Recommendation Report for Works to Tree(s) on trees subject to a Tree Preservation Order (TPO)

REF NO: AW/267/18/T

LOCATION: 8 Old Place
Aldwick
PO21 3AU

PROPOSAL: Remove 3 branches to 1 No. Eucalyptus tree.

ARUN DISTRICT COUNCIL AW/267/18/T

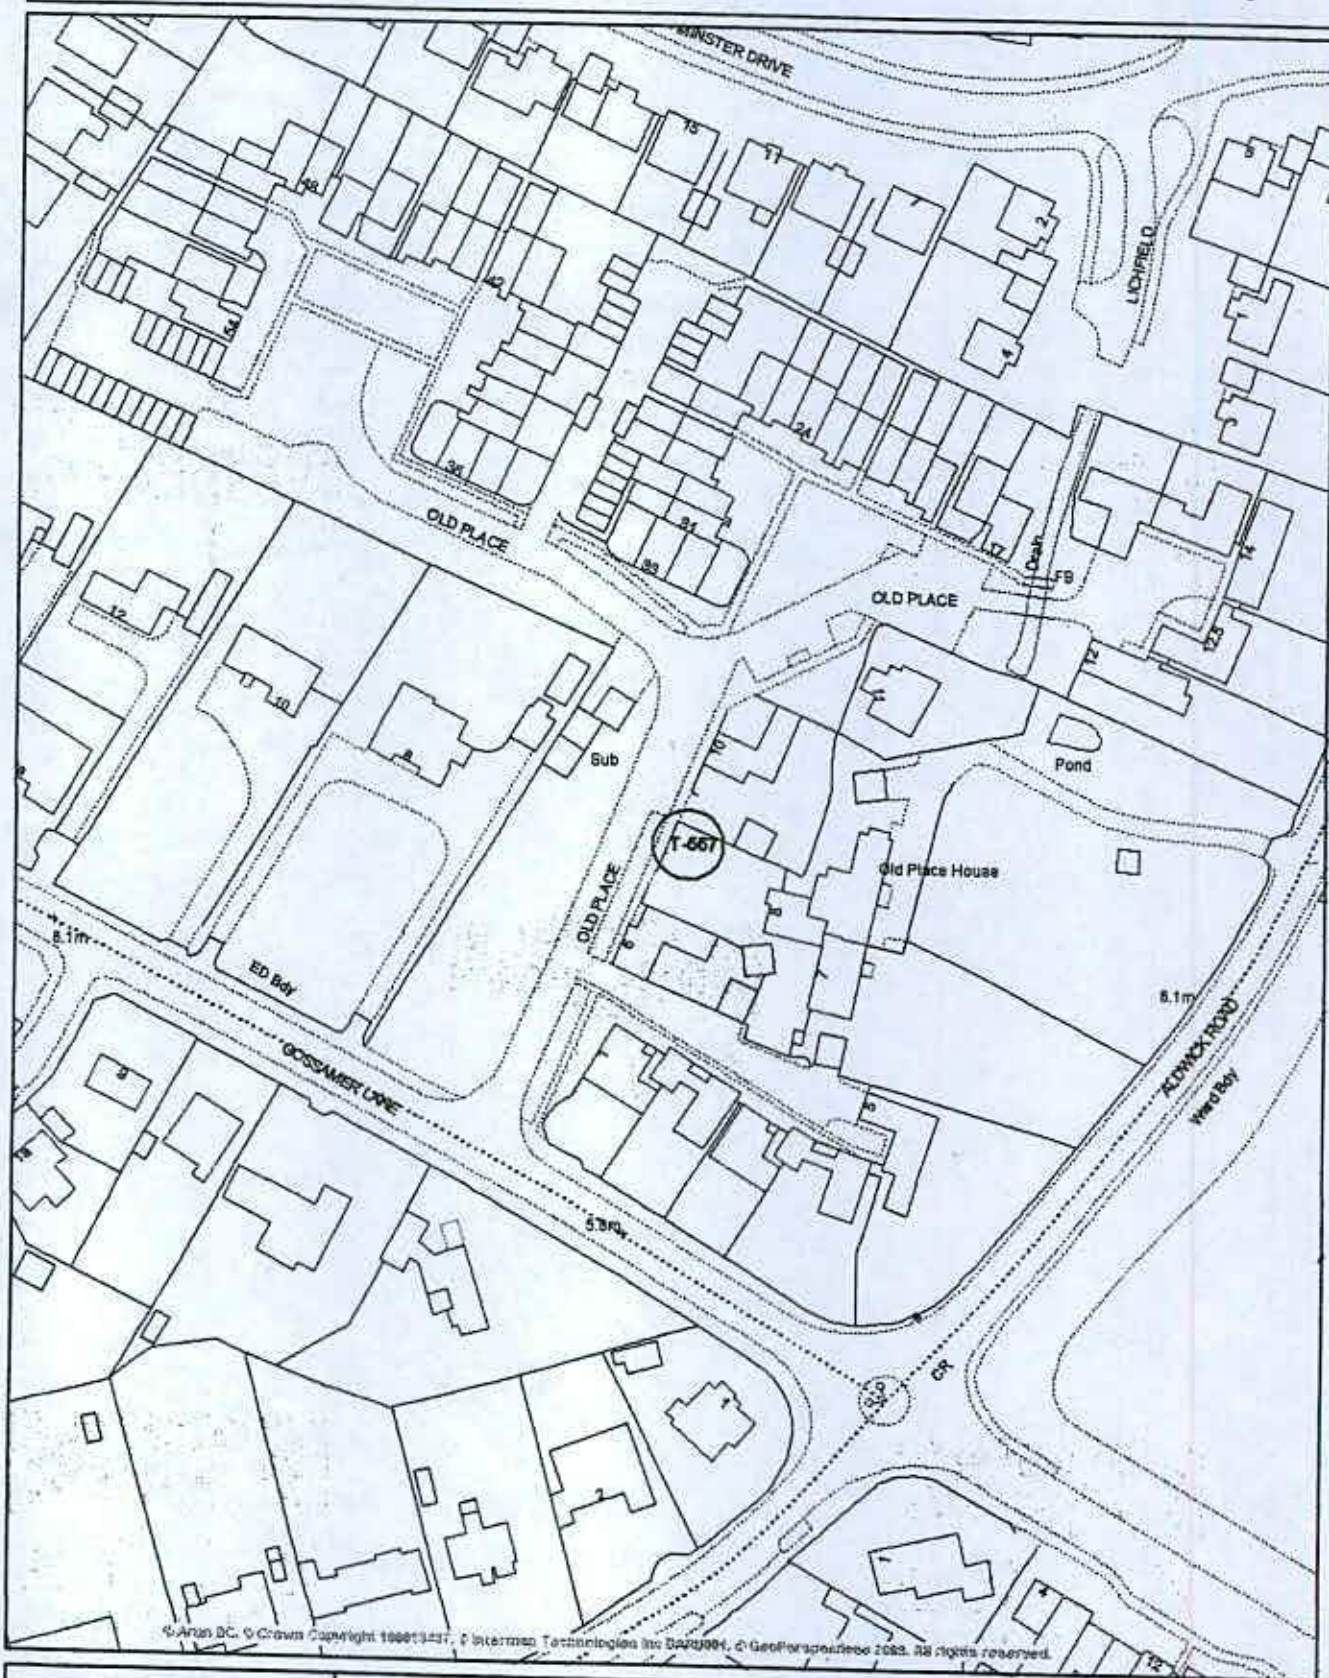
- This tree appears to be outwardly healthy, stable and free from obvious structural defect.
- It has a contorted main stem, a probable legacy of its early attempt to escape the shade of companion trees - from which it has emerged dominant.
- The upper limb and branch framework has achieved good symmetry and presents an attractive crown profile, albeit on an imperfect but nonetheless strong main stem.
- The tree is prominent at the front of the plot and is visible from adjacent property and public highway.

• The tree appears outwardly sound and no evidence of structural instability has been provided in support of the application.

• The tree is a notable feature in the local landscape and appears to be in adequately sound and healthy condition. The tree surgery proposed in the application has not been justified on arboricultural grounds.

• I recommend REFUSAL for this application.
